From: HALL James C [James.HALL@rms.nsw.gov.au]
Sent: Tuesday, 28 August 2012 11:14 AM
To: ben.eveleigh@planning.nsw.gov.au
Cc: LIN Xi; Andrew Johnson; tim.lewis@traffix.com.au; SHAH Kshitij;
Tim.Colless@wspt.nsw.gov.au
Subject: Horsley Drive Business Park - SSD 5169

I refer to your letter dated 6 July 2012 with regard to the abovementioned State Significant Development, which was referred to the Roads and Maritime Services (RMS) for review and comment.

DRAWING TITLE: CONCEPT STORMWATER FINISHED LEVELS PLAN SHEET 1
DRAWING No: C011492.00-DA4-1-1

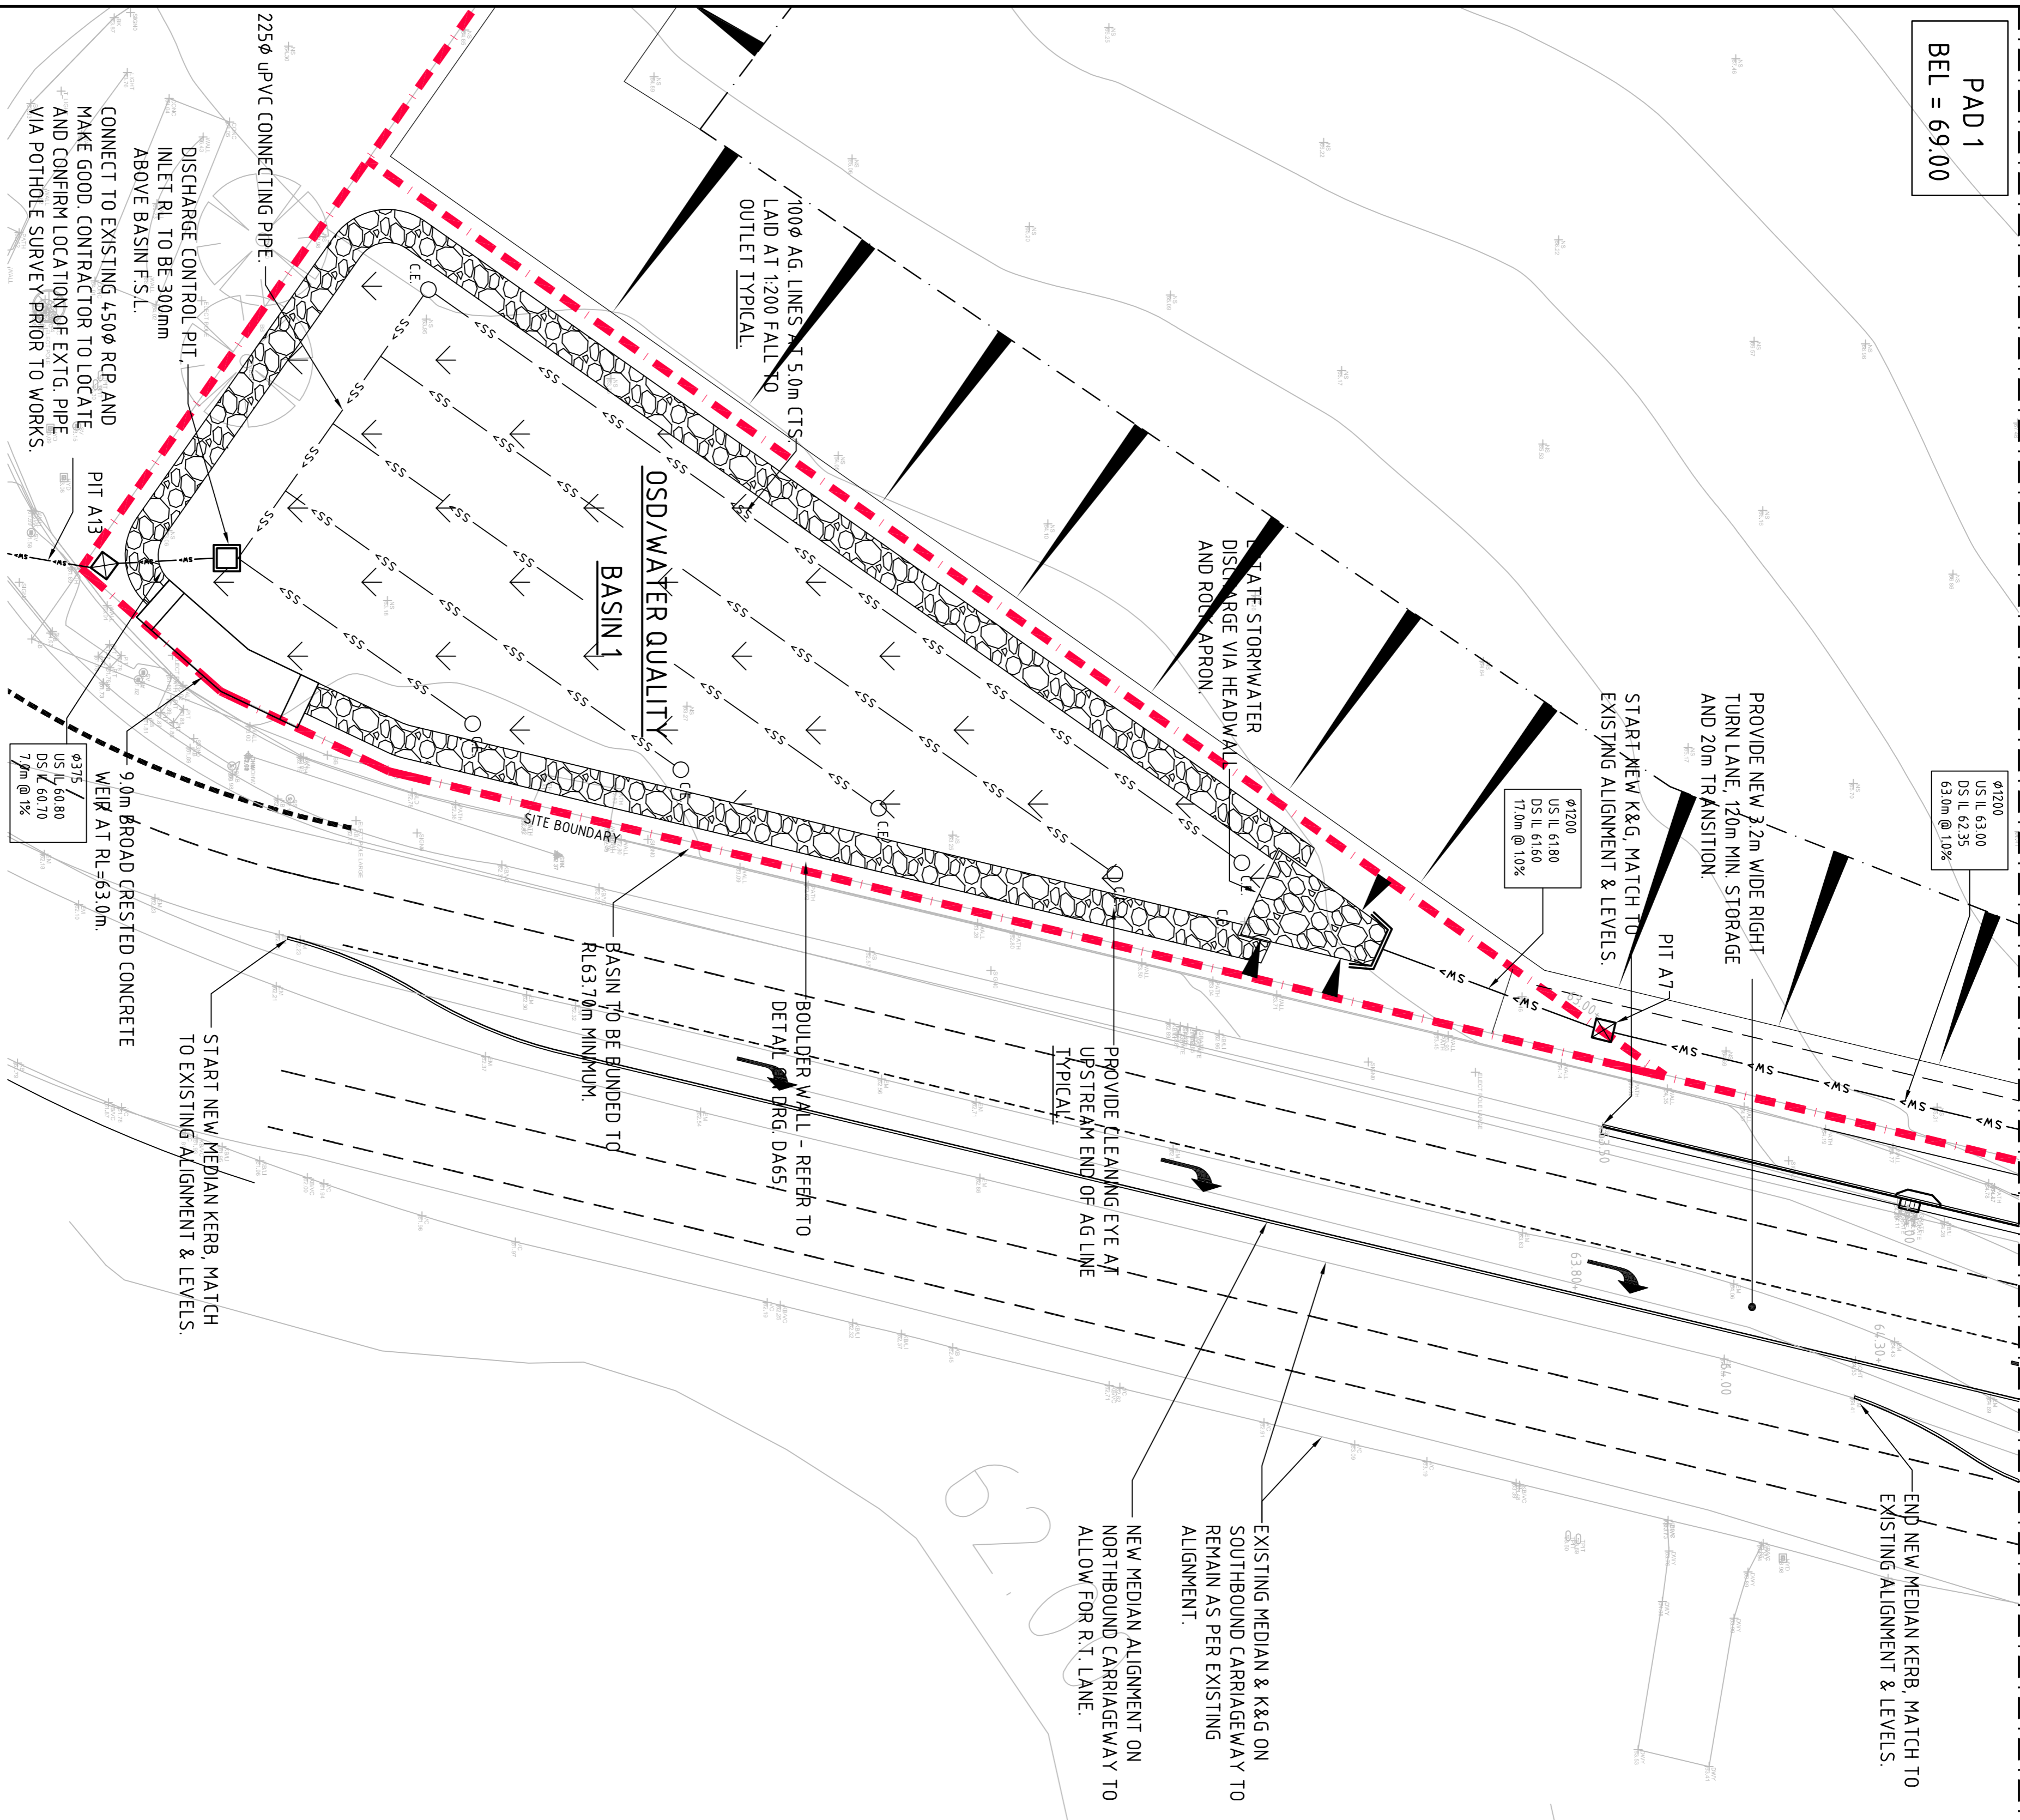
- Warrants being satisfied for the proposed traffic signals at the intersection of Cowpasture Road/Newton Road/Access Road.
- A concept road design layout of the proposed signalised intersection overlayed on a survey plan to ensure that it can be physically constructed within the existing road corridor.
- Further information on the type of land use activity in order to determine employment density, which will provide an indication on the number of parking spaces required for the proposed development.
